Our Ref: WA/26/18/OUT
Your Ref:

Town & Country Planning Act 1990 (as amended)
Town & country Planning (Development Management Procedure) (England) Order 2015 - Article
5
Application for Outline Consent

Development Outline application with all matters for 6 No detached houses with detached garages.
This application is a Departure from the Development Plan.

Location Former Lanes End House Adjacent to West Walberton Lane & Arundel Lane
Walberton

Block Plan shows area bounded by: 495692.11, 106831.95 495782.11, 106921.95 (at a scale of 1:500), OSGridRef: SU9573 687. The representation of a road, track or path is no evidence of a right of way. The representation of features as lines is no evidence of a property boundary.

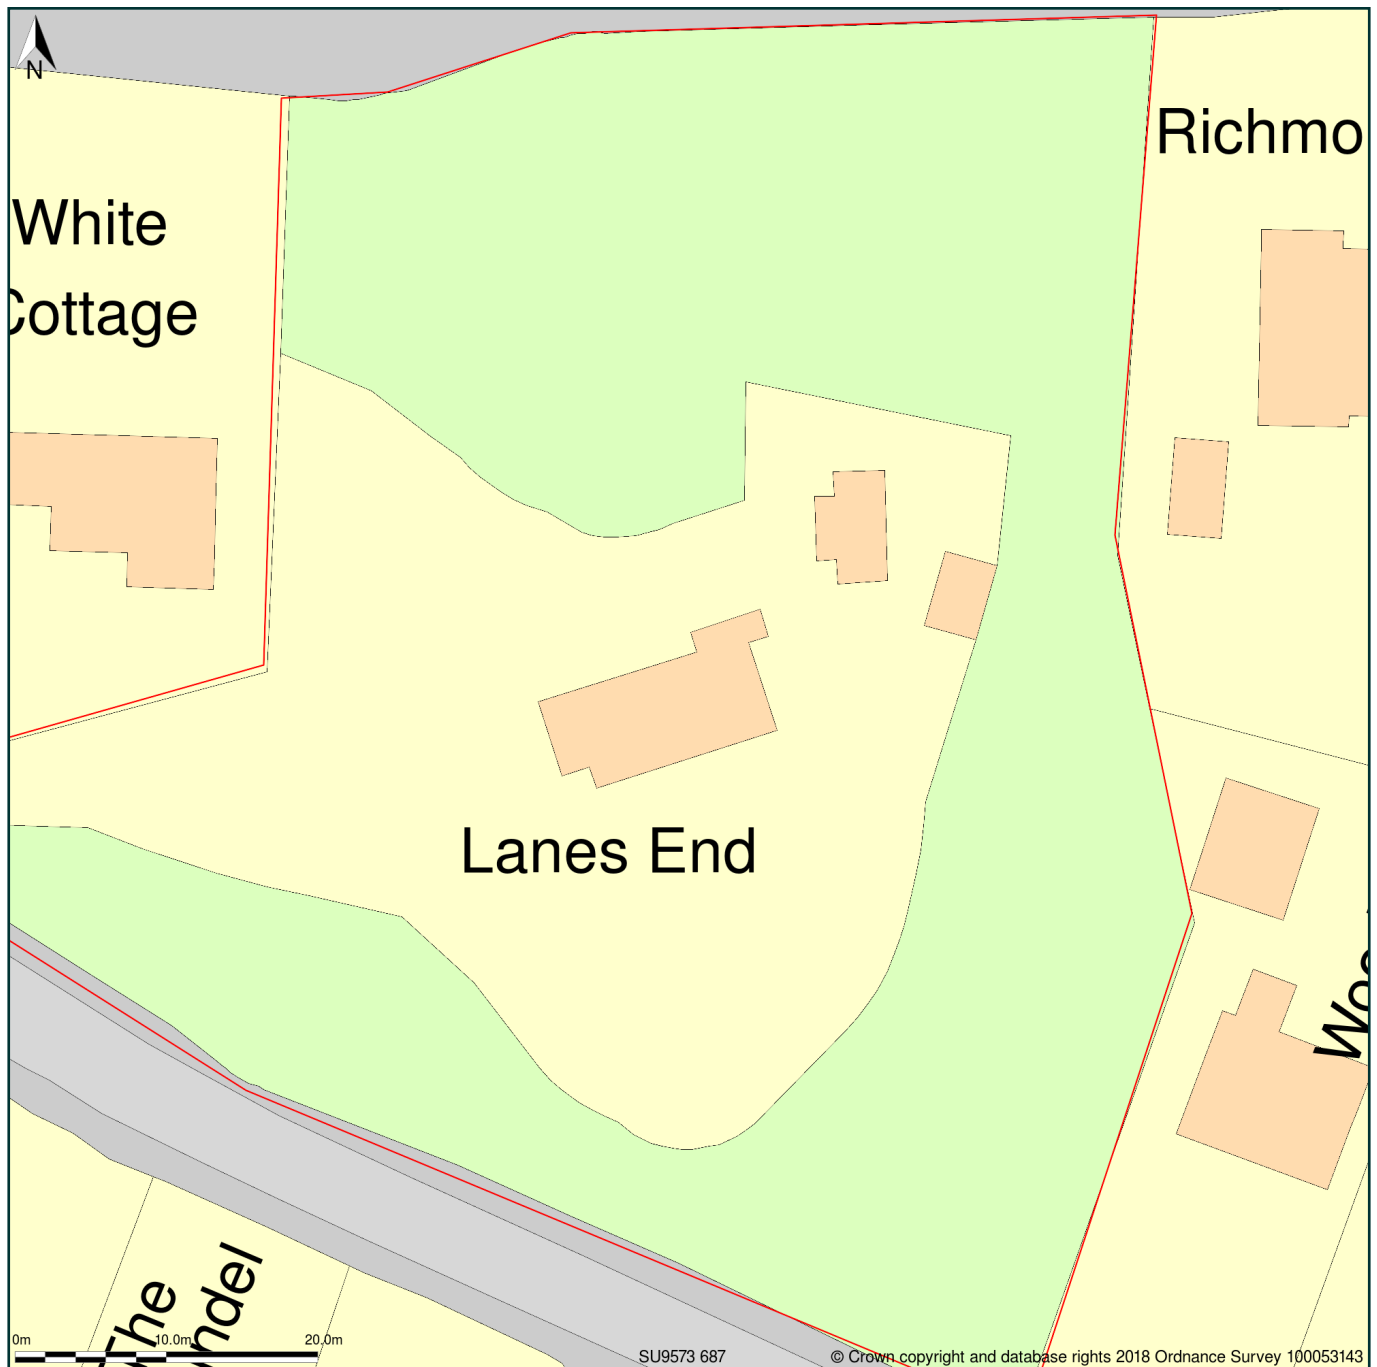
Block Plan Amend

Please submit 1 electronic or 3 paper copies of a block/site plan at a scale of 1:500 or 1:200. Further details of what must be included on the plan can be found in the National Validation Requirements. Please provide a full block plan.

Former Lanes End - Six Six bedroom detached Houses with Garages Proposed Layout Scale 1:100 @ A3 (c) PJ Developments LTD 2018		REVISIONS		01
		MM/DD/YY	REMARKS	
	1	--/--/--	...	A
	2	--/--/--	...	
	3	--/--/--	...	
	4	--/--/--	...	
	5	--/--/--	...	
West Walberton Lane Proposal

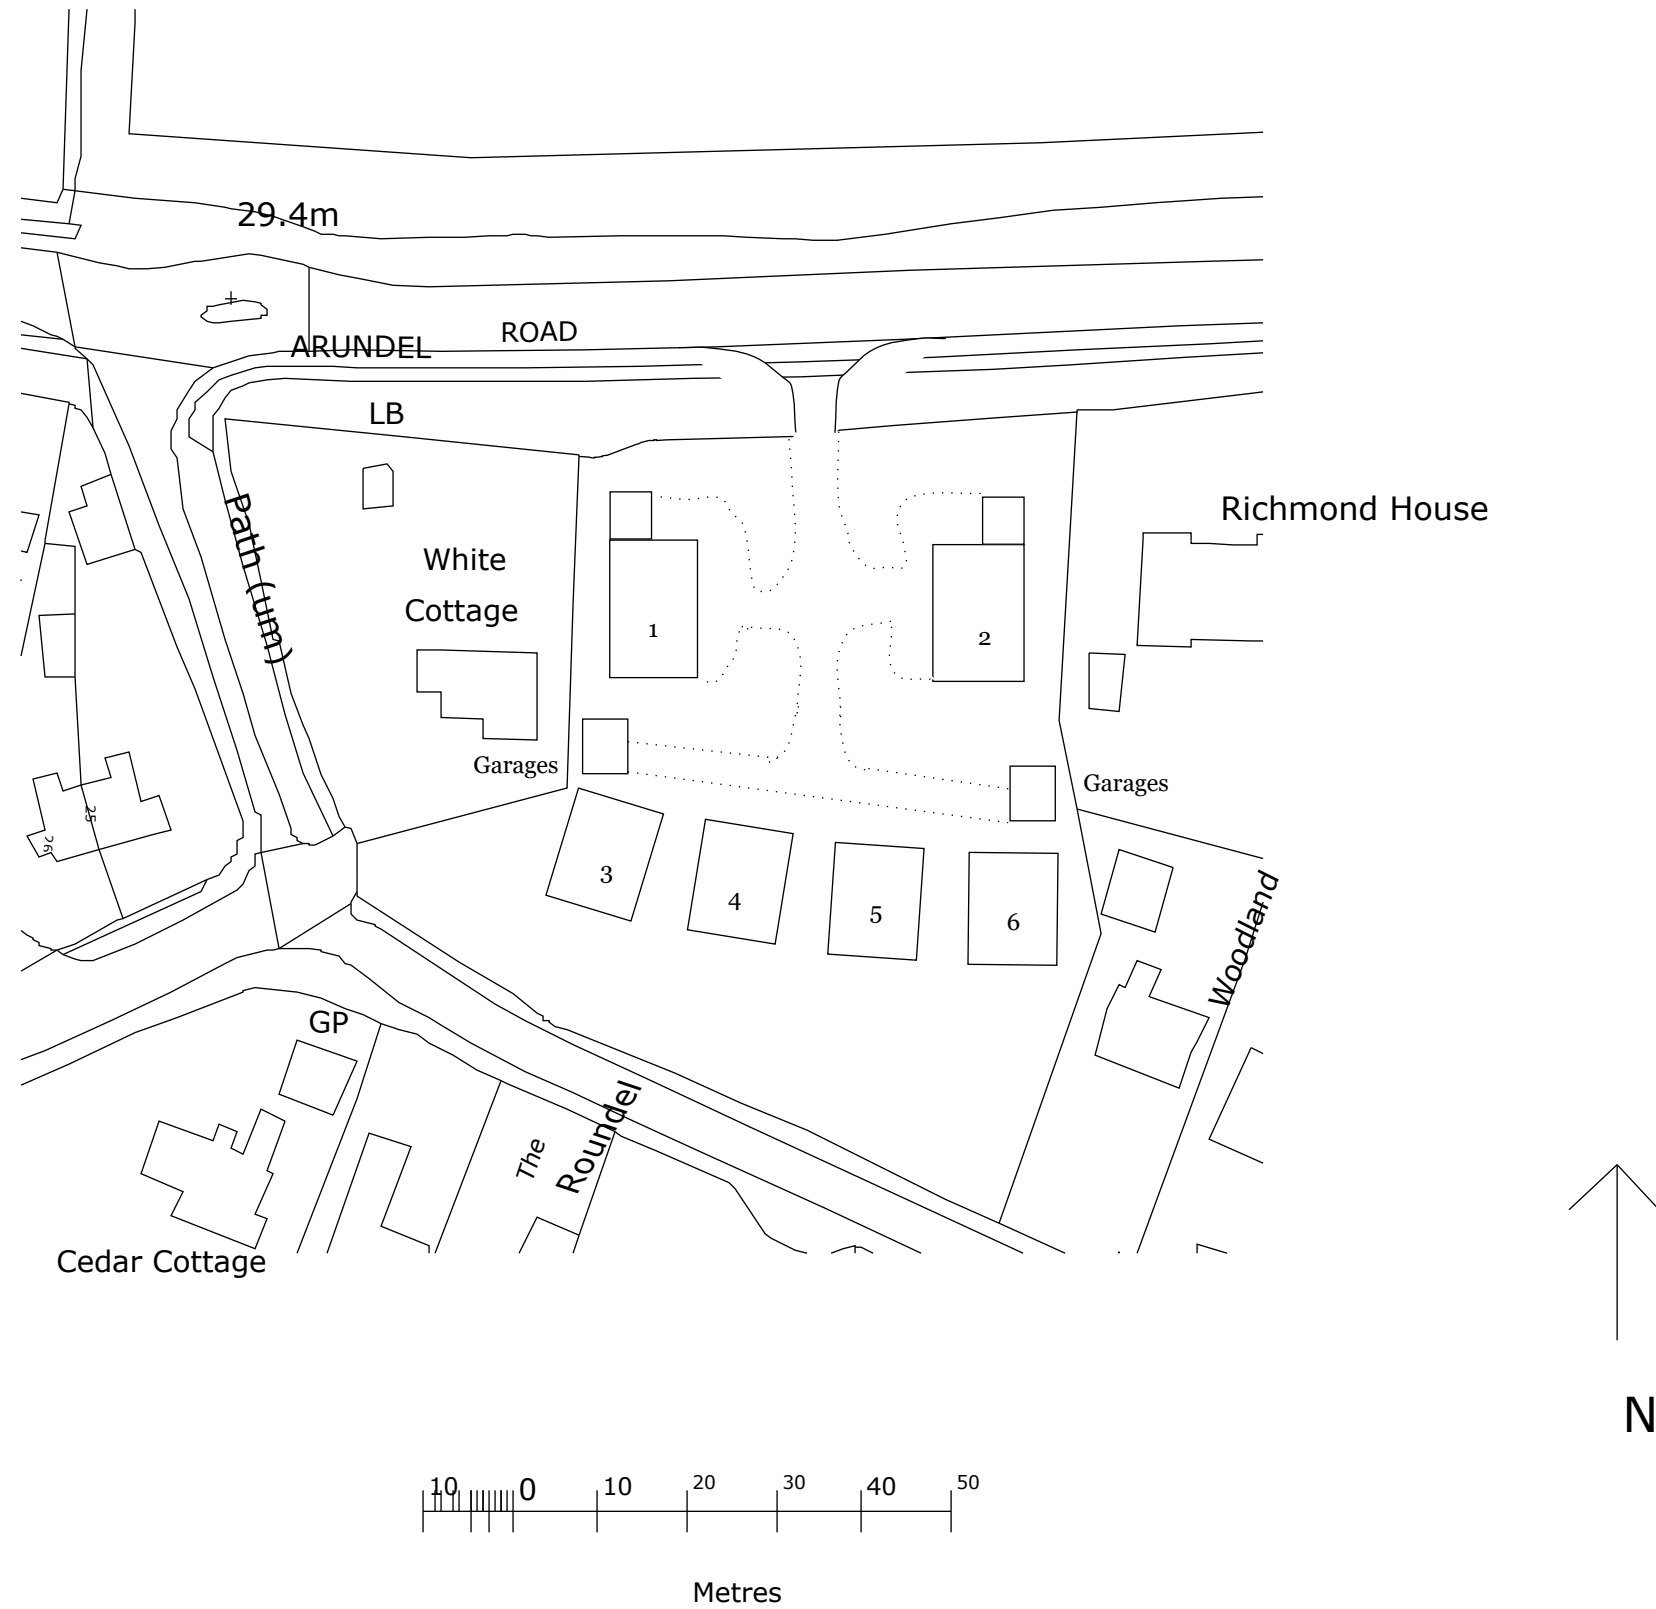
Please provide a scale on the Proposed Layout Plan.
